Our Ref: TR040011

Planning Act 2008 – Section 51

Application by North Somerset District Council for an Order Granting Development Consent for the Portishead Branch Line – MetroWest Phase 1

Advice following issue of decision to accept the application for Examination

Figure N-5: Pre Development, 75year return period event in 2015 ,Tidal

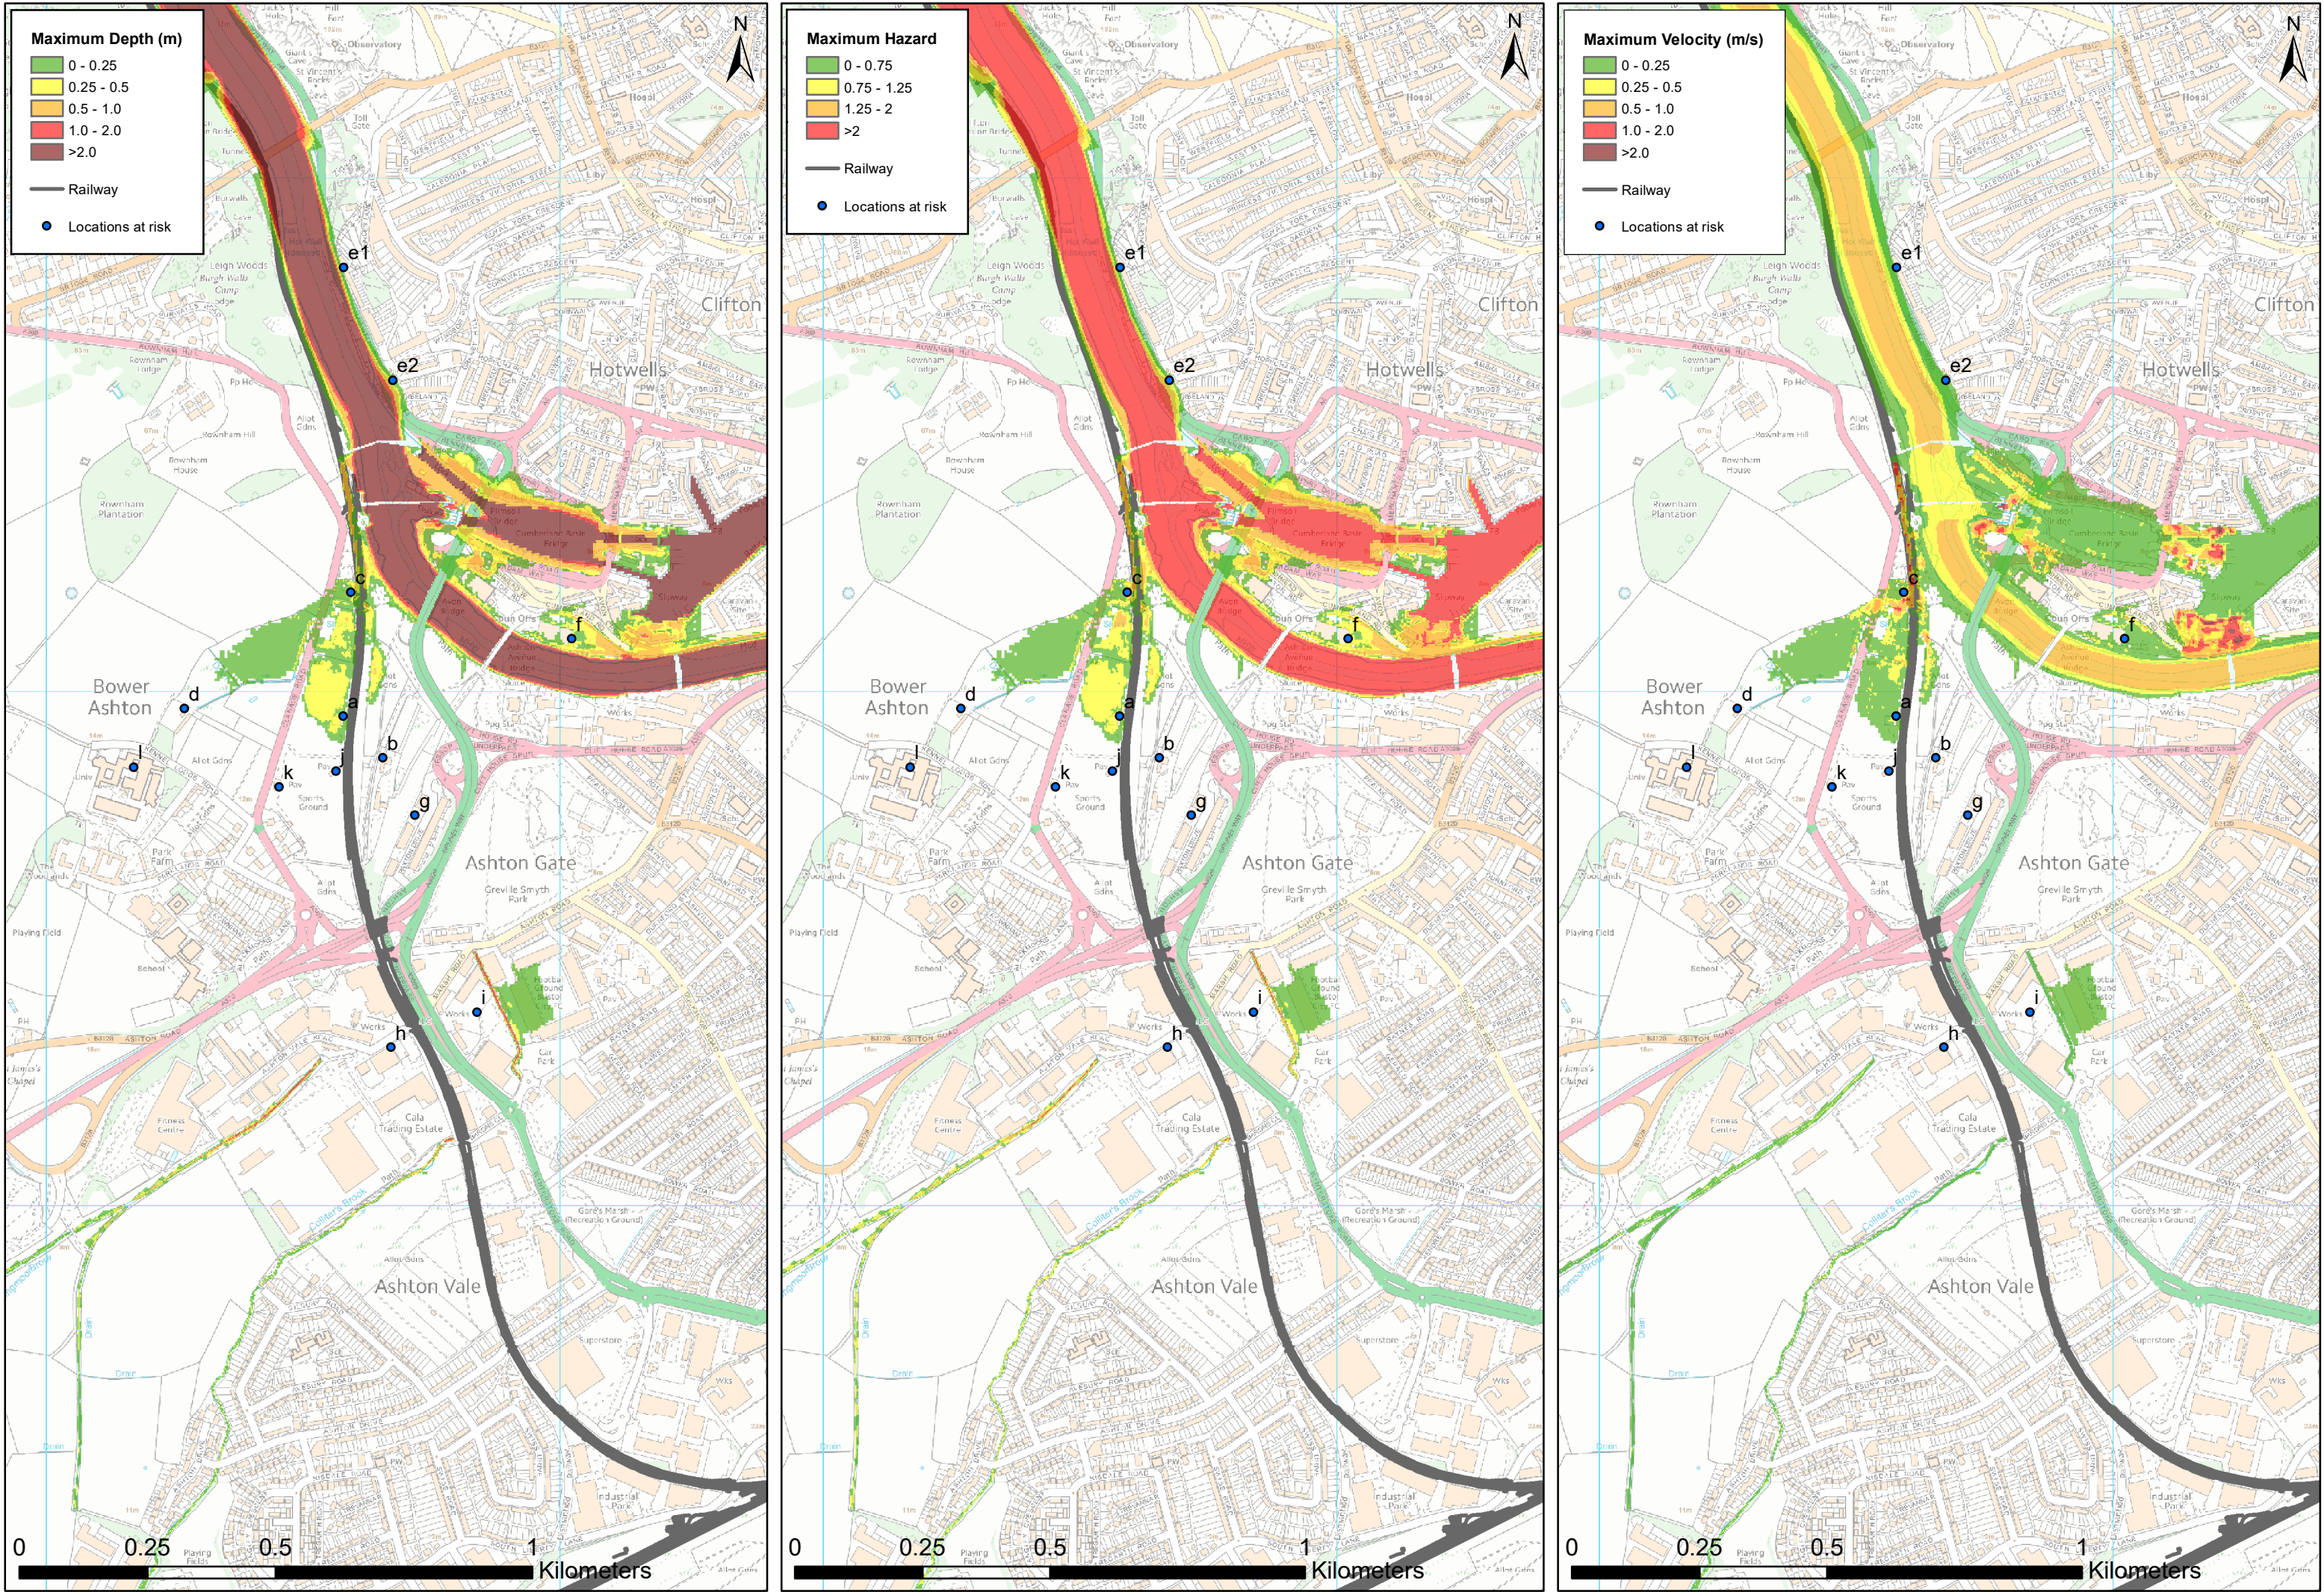
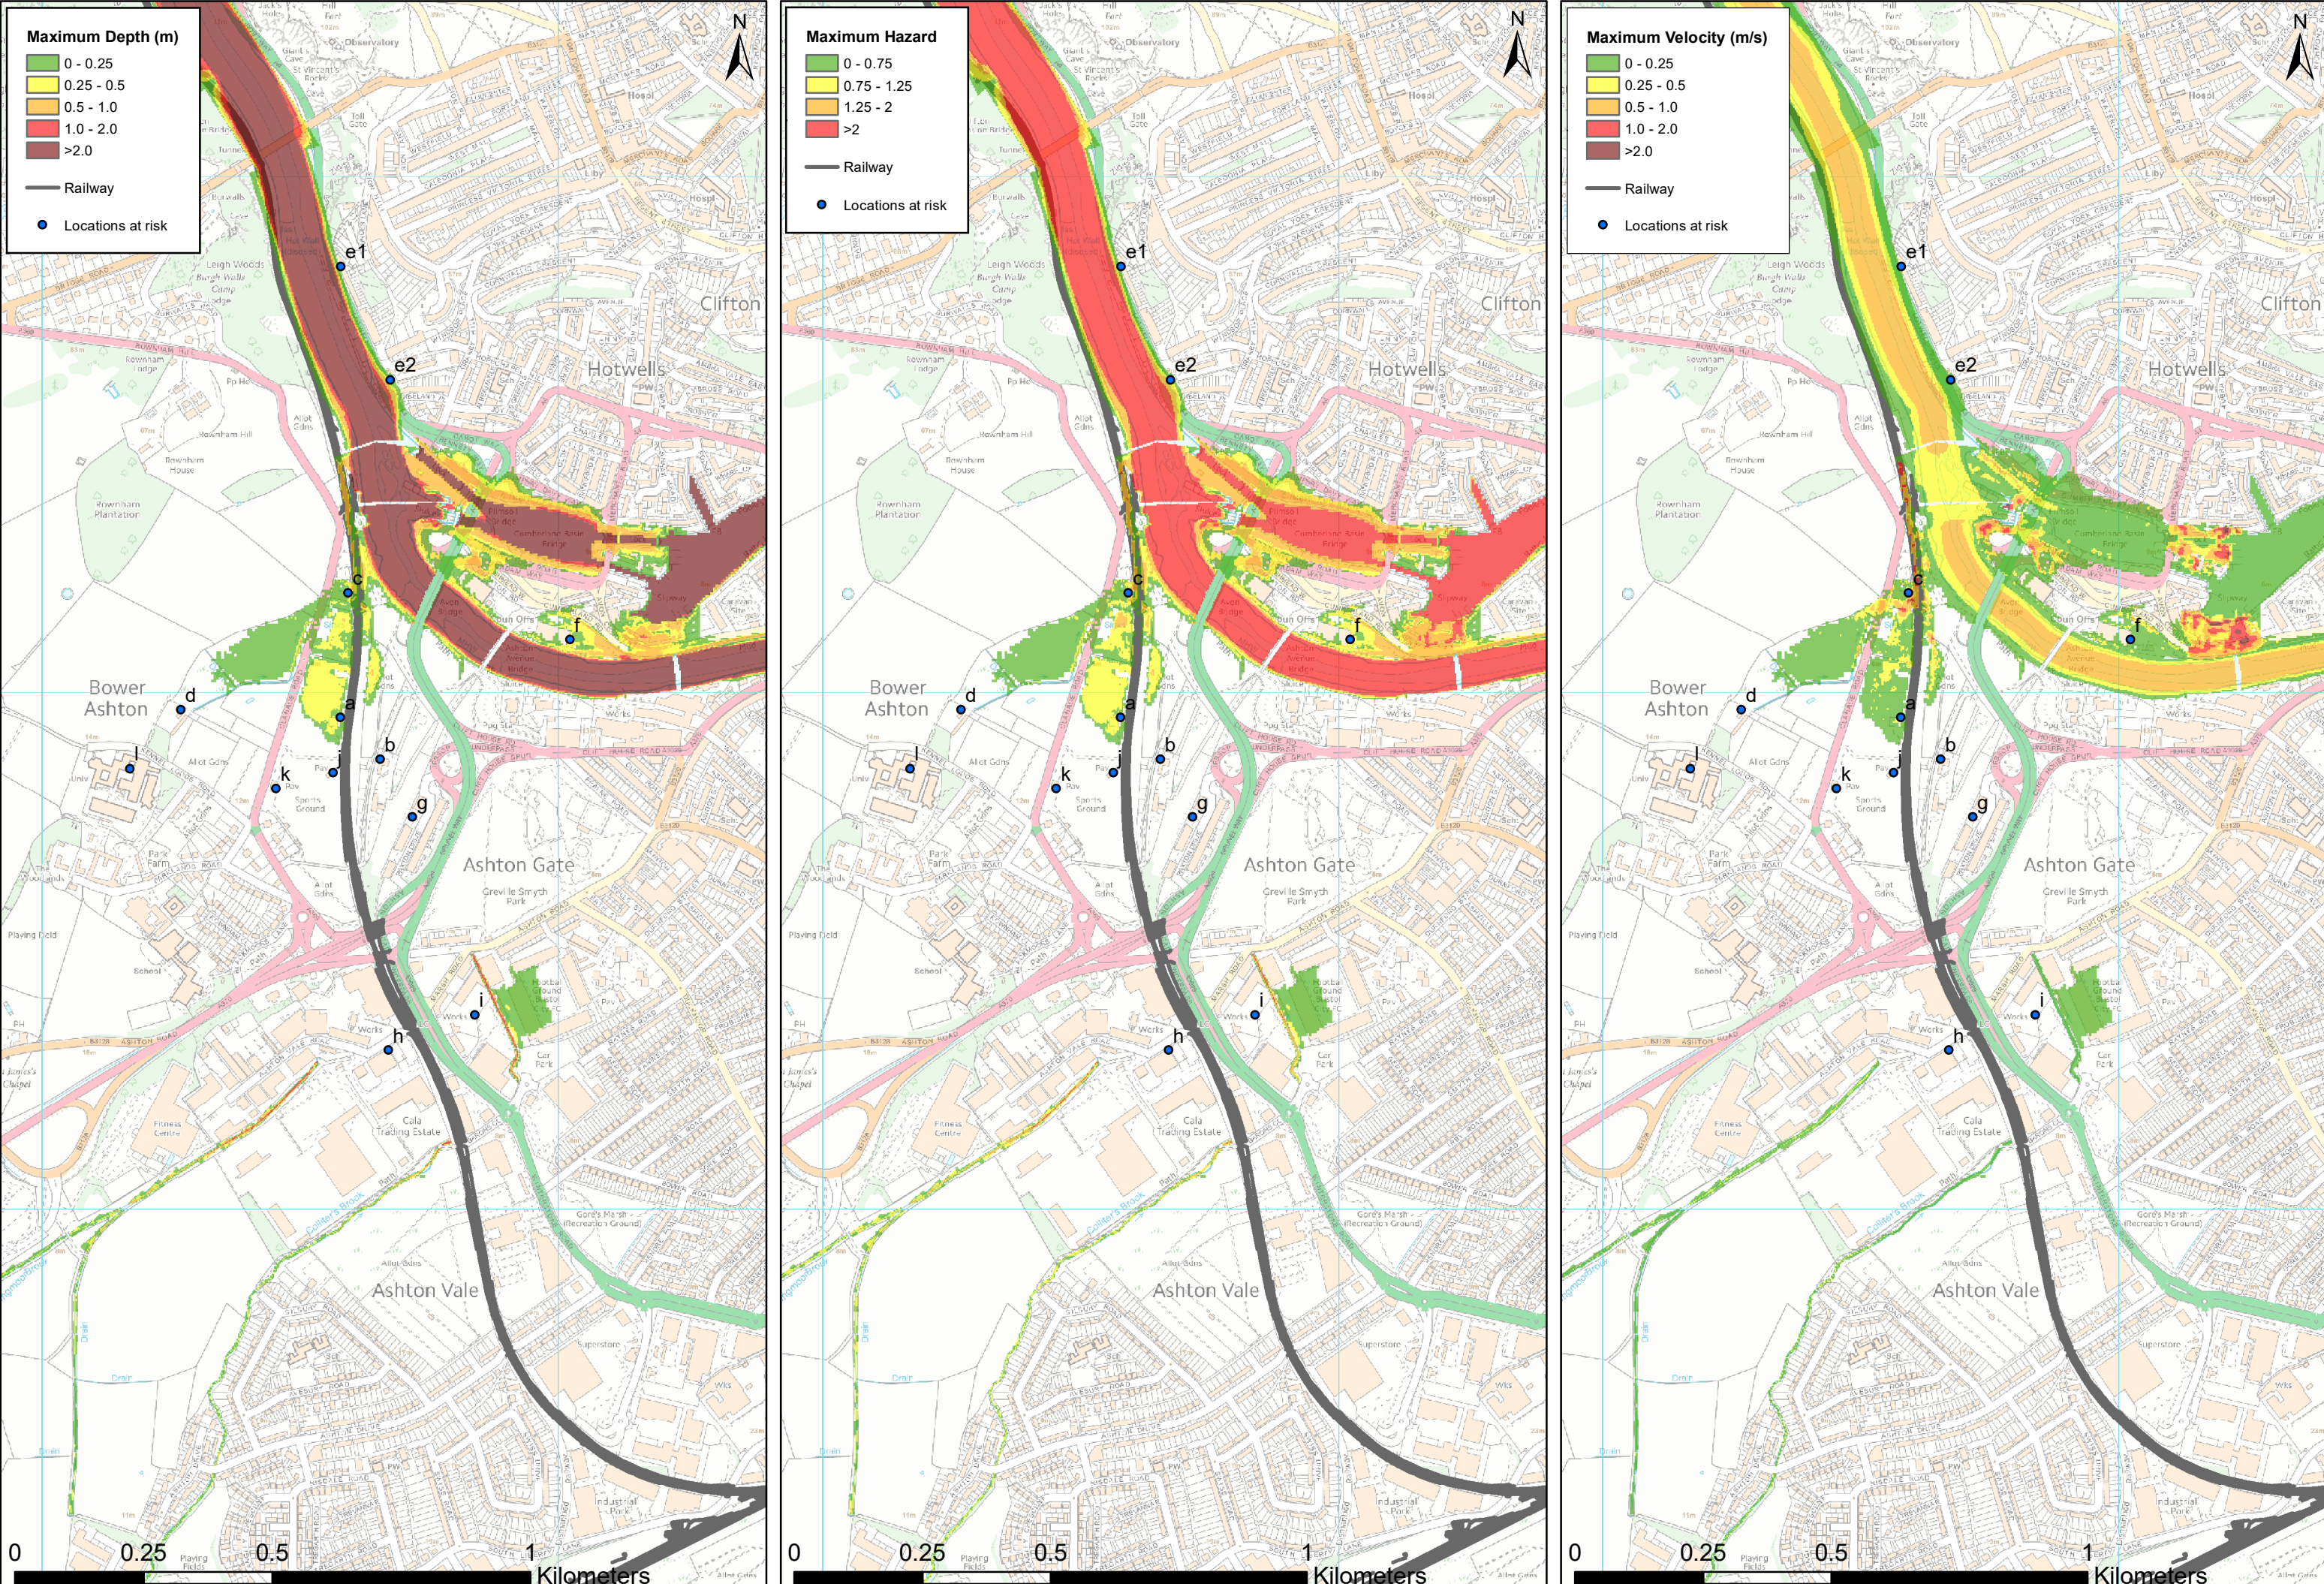
At Bower Ashton - the simulation of impacts from River Avon tidal flooding indicates that this section of the operational NSIP would experience tidal flood events once every 5 to 10 years for the assessment year (taken to be 2015) and more than once a year on average in the future (scenarios 2075 and 2115) (taking into account climate change, including sea level rise, into consideration). In preparation for the examination the Inspectorate seeks to understand the extent to which the application of the revised climate change allowances may (or may not) affect the findings in this regard. In particular, whether such detail would result in anticipated flood events at more frequent intervals and at earlier points in the design life of the Proposed Development.
